Application Ref:	2025/0125			 Ribble Valley Borough Council www.ribblevalley.gov.uk
Date Inspected:	16/04/2025	Site Notice:	16/04/2025	
Officer:	EP			
DELEGATED ITEM FILE REPORT:				APPROVAL

Development Description:	Proposed removal of six floodlights and replacement with four floodlights with LED luminaires.
Site Address/Location:	Clitheroe Football Club Ltd Shawbridge Street Clitheroe BB7 1LZ.

Client: Clitheroe Football Club Ltd.		
Project: Proposed Floodlighting EcoGiants Stadium Shawbridge Pendle Road Clitheroe		
Dwg title: Proposed Elevations & Sections		
Scale @ A1: 1:200	Date: 02.03.25	Drawn by: PD
Drawing no. 1716 - 06		Rev. -

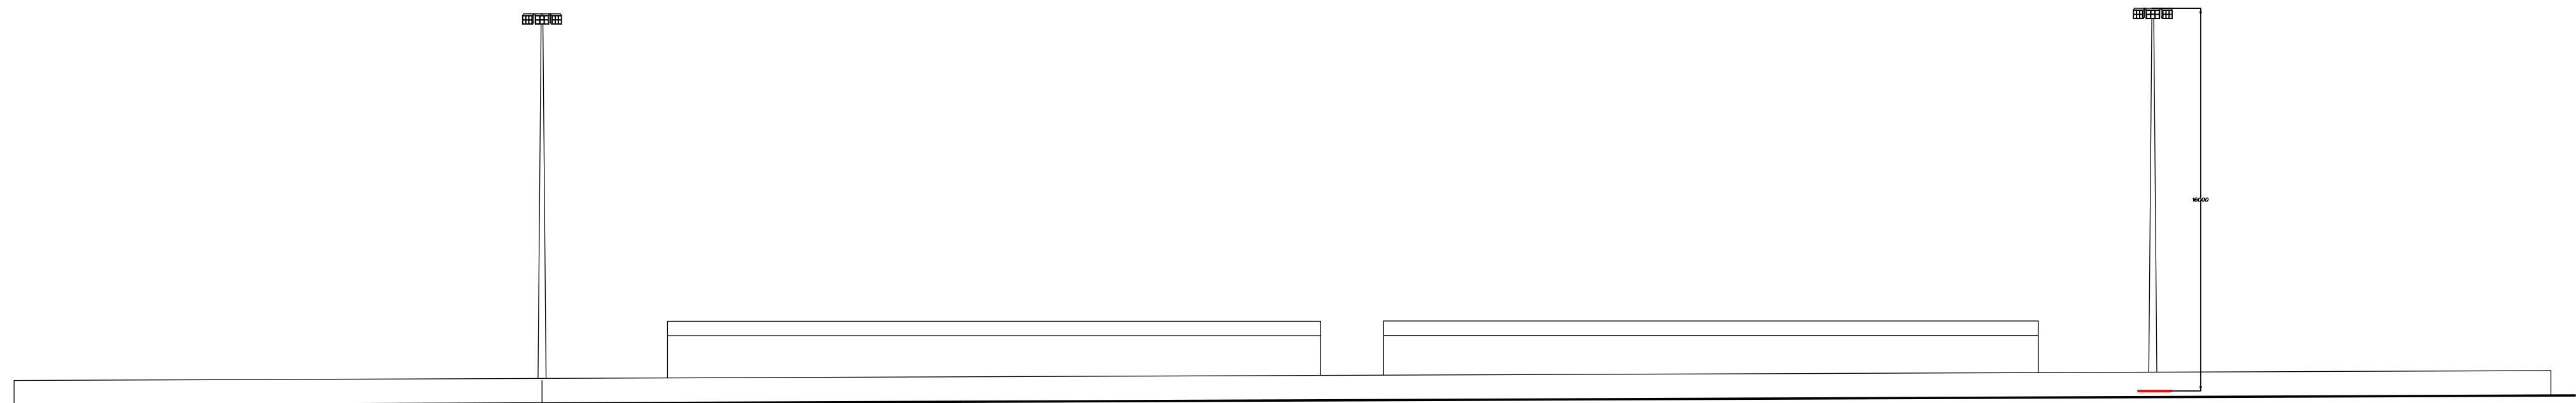
The proposed masts will measure 15m in height and will be located to the four corners of the site. The existing floodlight masts, of which there are 6, measure 16m in height. Therefore, the proposed development, by virtue of the reduction in number of masts and slight reduction in height, will have less visual prominence than the existing development.

Client: Clitheroe Football Club Ltd.		
Project: Proposed Floodlighting EcoGiants Stadium Shawbridge Pendle Road Clitheroe		
Dwg title: Proposed Site Plan		
Scale @ A3: 1:500	Date: 09.02.25	Drawn by: PD
Drawing no. 1716 - 03	Rev. A

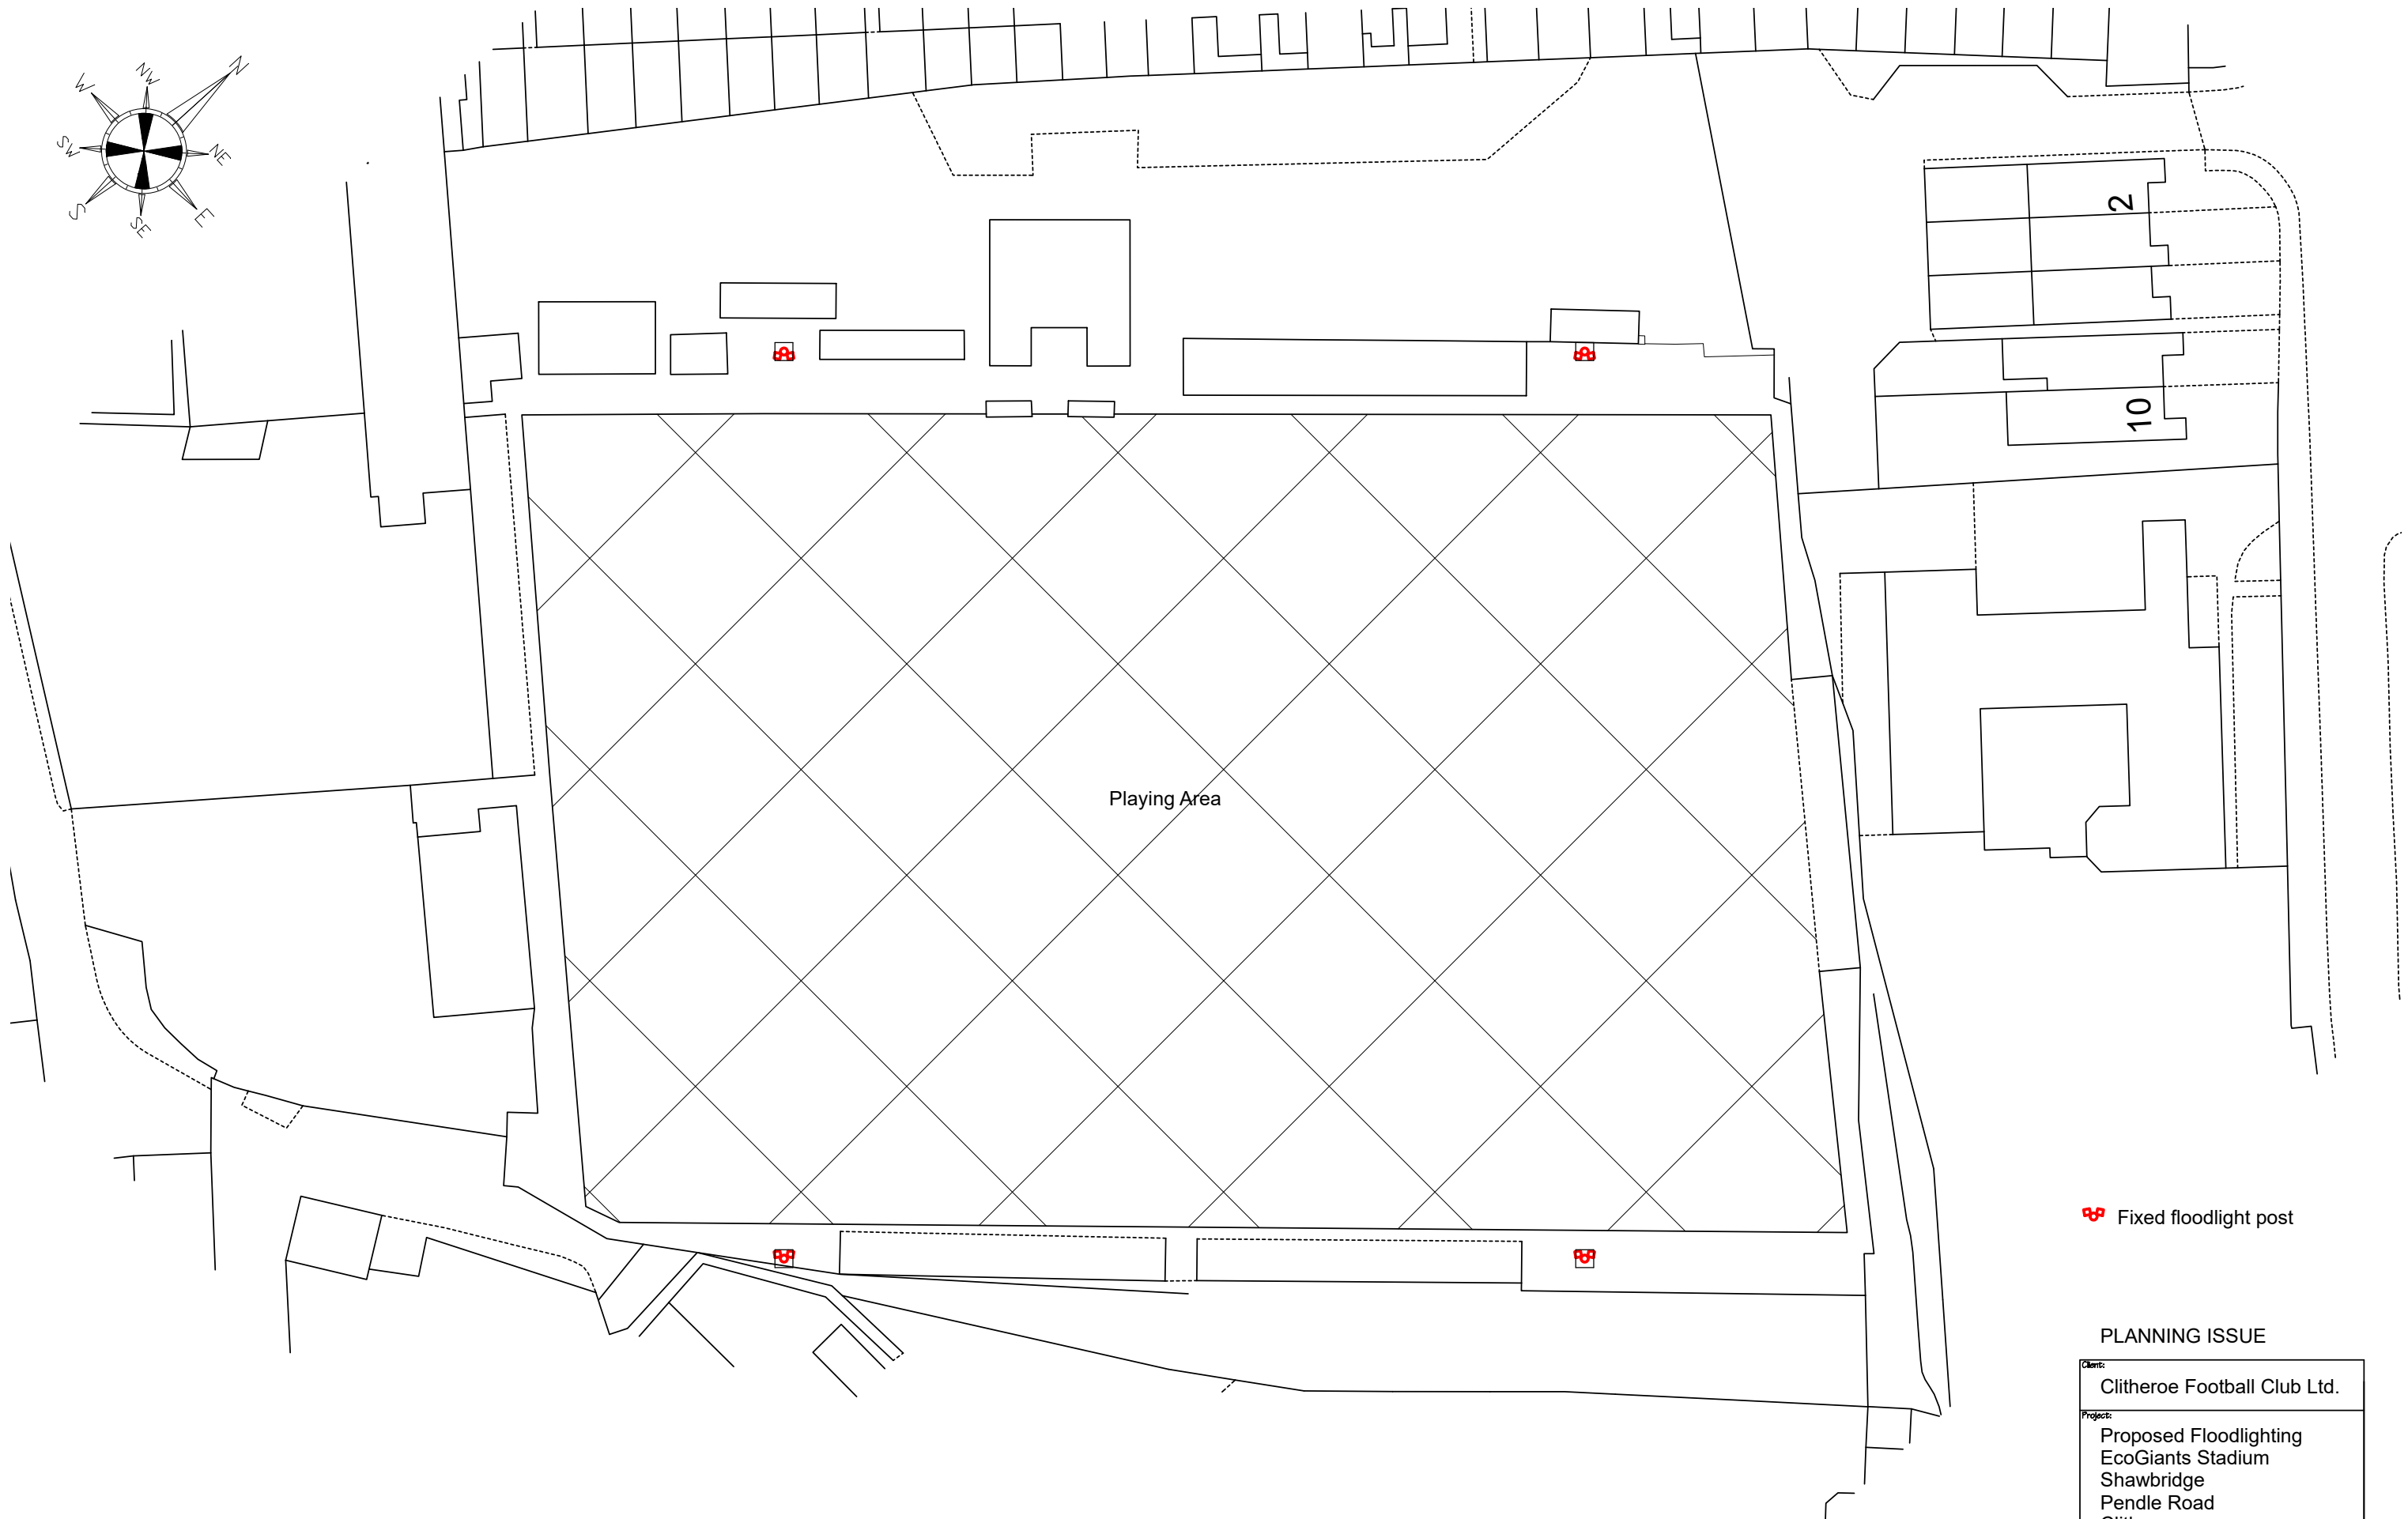
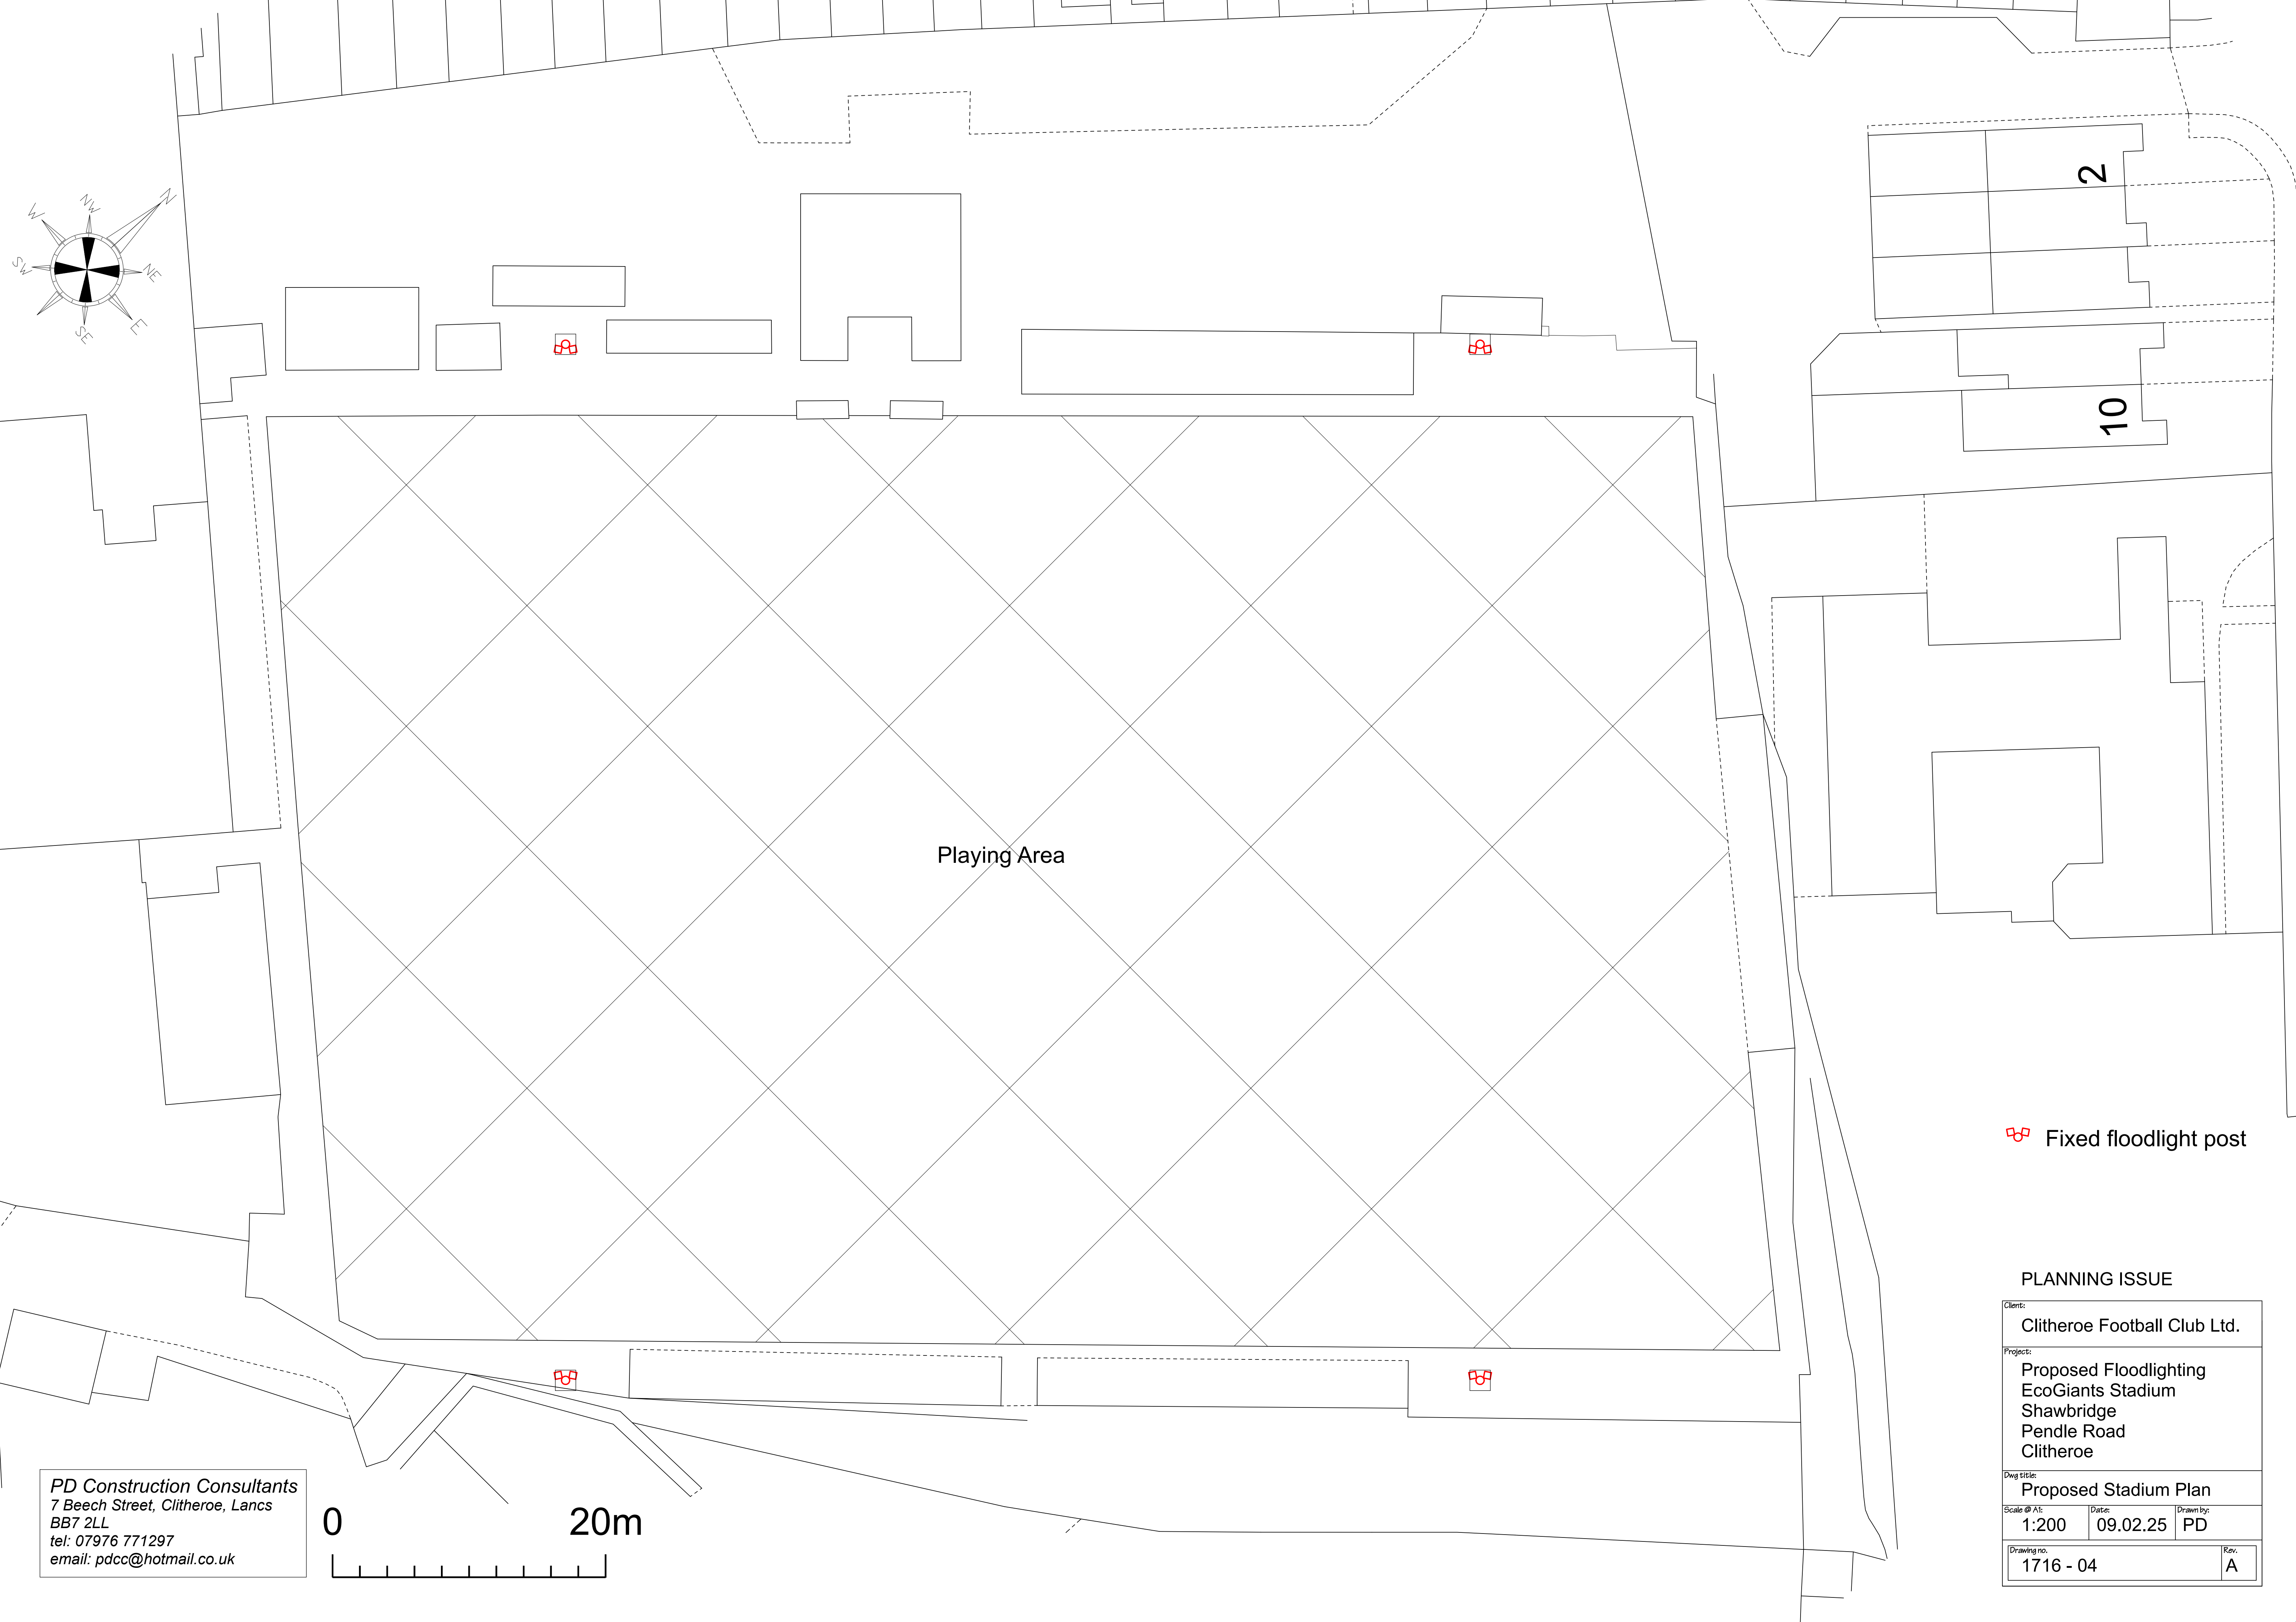
Consent is sought for the replacement of the existing floodlight masts with new. There are 4 masts proposed which will be located at the four corners of the pitch.

The existing site benefits from 6 floodlight masts around the perimeter of the football pitch, with the football club itself having a longstanding existence within the area. The proposed development comprises a reduction in masts and associated lighting, proposing just 4 to each corner of the pitch. As such, despite the development being within close proximity to residential amenity, it is not considered the proposal would result in a substantial increase in light pollution when compared with the existing arrangement given the reduction in number.

The proposed lighting will face towards the football pitch in a downward direction and not directly toward any neighbouring residential property. The proposed lighting, being 15m above ground level, will sit well above the existing roofline of neighbouring houses. The taller the lighting, the easier it is to direct the lighting downward. The proposed lighting will therefore not result in direct glare to neighbouring windows as a result of this.
